**KIRKLEES METROPOLITAN COUNCIL
INVESTMENT & REGENERATION SERVICE**

**DELEGATED DECISION TO DETERMINE APPLICATIONS FOR
NON-MATERIAL AMENDMENTS**

Reference No: **2025/NM/91178/E**

Description: Non material amendment to previous permission
2021/90772 for erection of single and two storey rear
and single storey side extensions

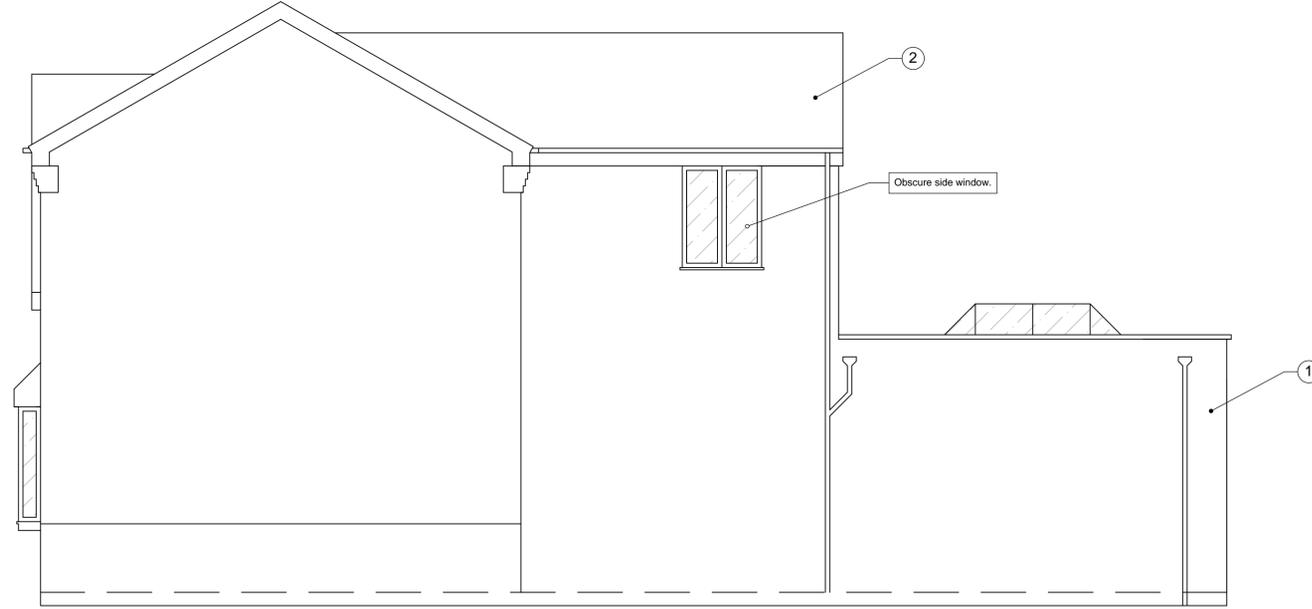
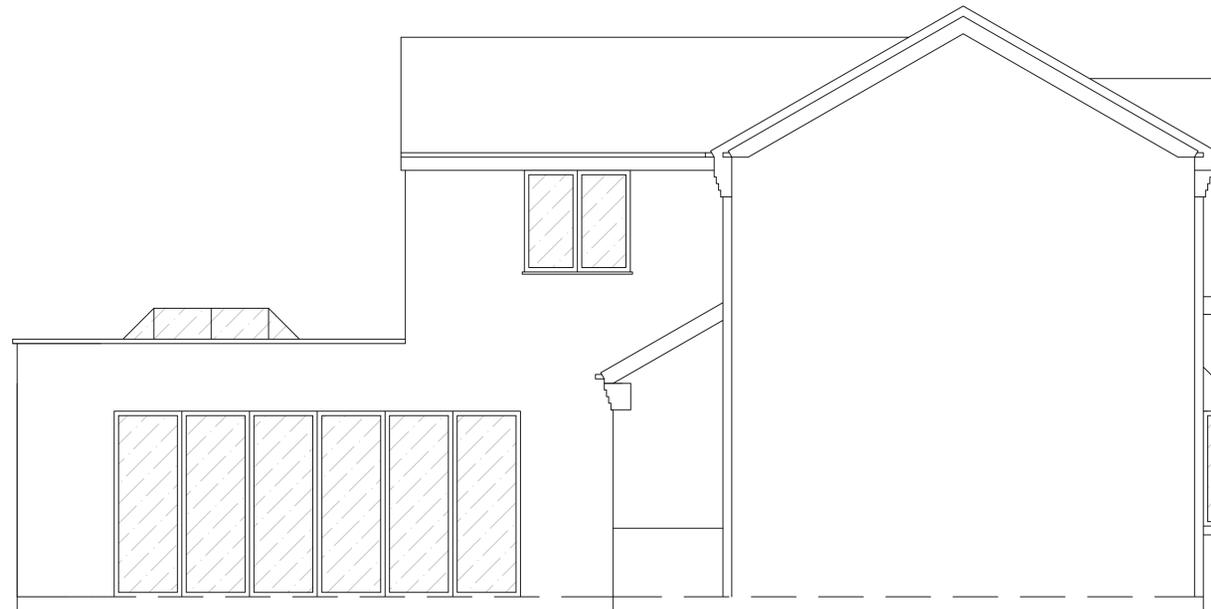
The amendment seeks to include a first floor extension over the side extension. The amendments are shown on the plans submitted 29/04/2025.

For the reasons outlined above, the enlargement of the side extension from the originally approved scheme requires full assessment. The amendment which is proposed goes beyond the scope of that which could be considered to be a non material amendment and would need to be assessed as part of an application for planning permission.

The proposed amendments would increase the size and scale of the extension such that an assessment of the scheme in relation to visual impact / impact upon neighbouring occupiers is required to be undertaken. Such an assessment would need to be undertaken having regard to any representations following publicity of the development proposal.
